Proposal: Discharge of Condition 4 (stone sample panel) of 22/01444/F

Document titled Stone (Condition 04) by Squire & Partners reference 20064 dated February 2023, including the stone sample panel constructed on site (Figs. 5 and 6).

Fig. 5 - Grange Hill Cream sample panel built on site

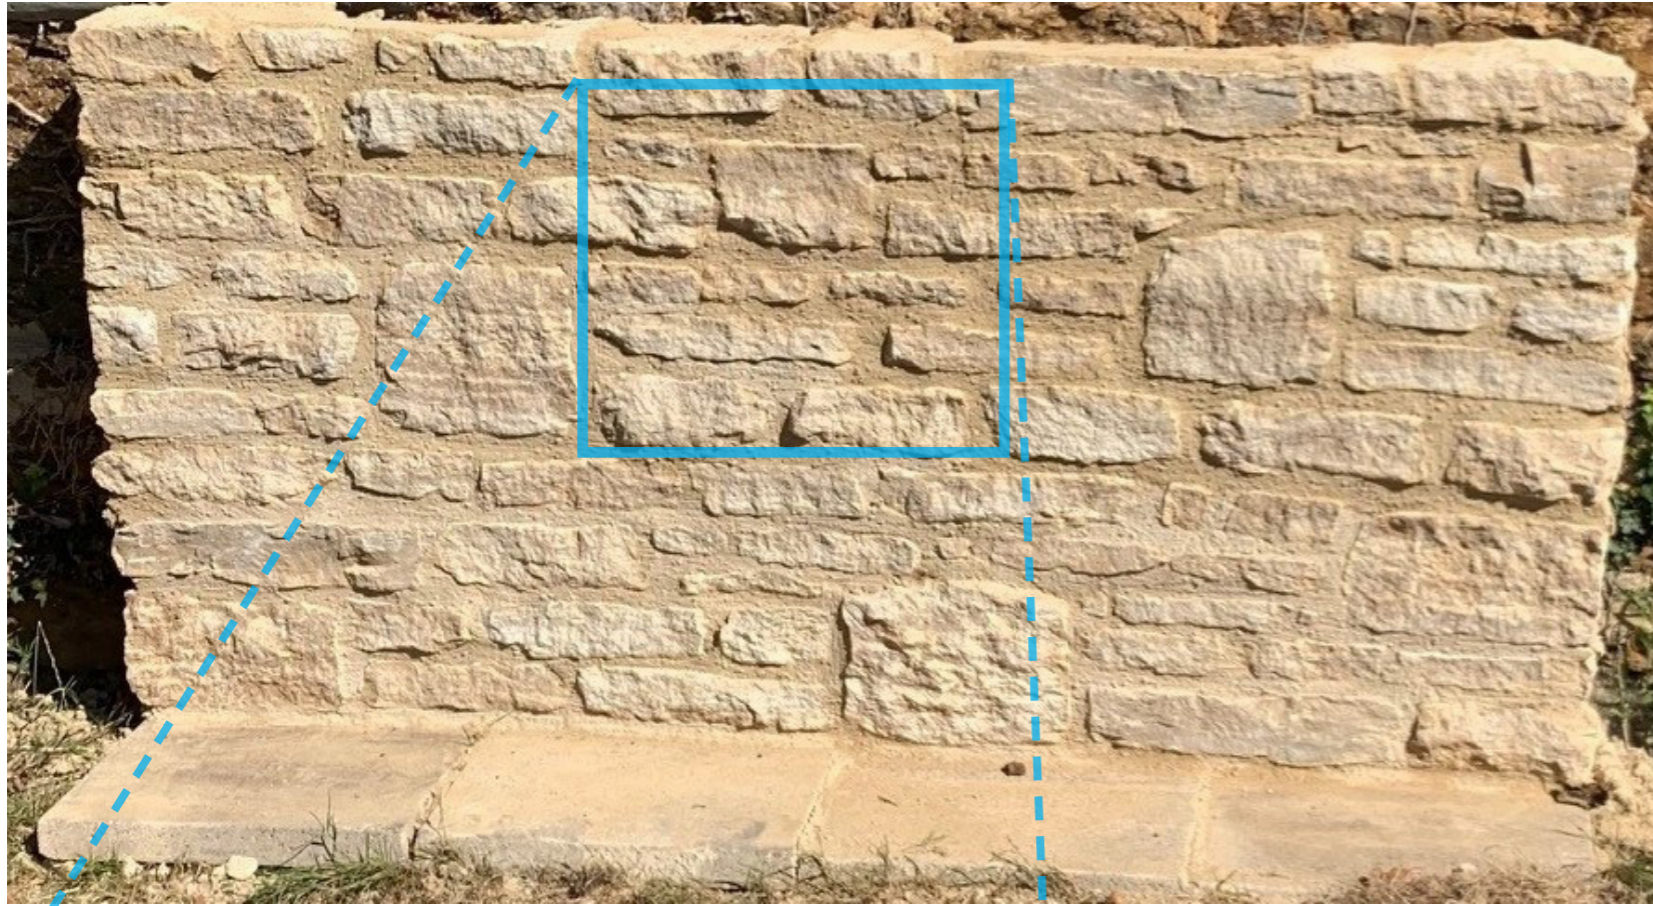
- 5.2 As originally shown the stone panel included a number of larger blocks acting as 'jumper' stone which stretched across two courses. This is not a feature used in the village and as such not a feature encouraged nor supported.
- 5.3 The applicant has changed the stone panel to remove this feature and have a variety of stone sizes but in level courses which is more in line style and character with the village. The Conservation Officer was included in the earlier negotiations and agrees that the Grange Hill Cream is acceptable.

Some of the joints in the stone sample panel are inappropriately and unnecessarily thick and the developer should make concerted efforts to lay the stonework with tighter joints, working to a maximum joint thickness of 10mm.
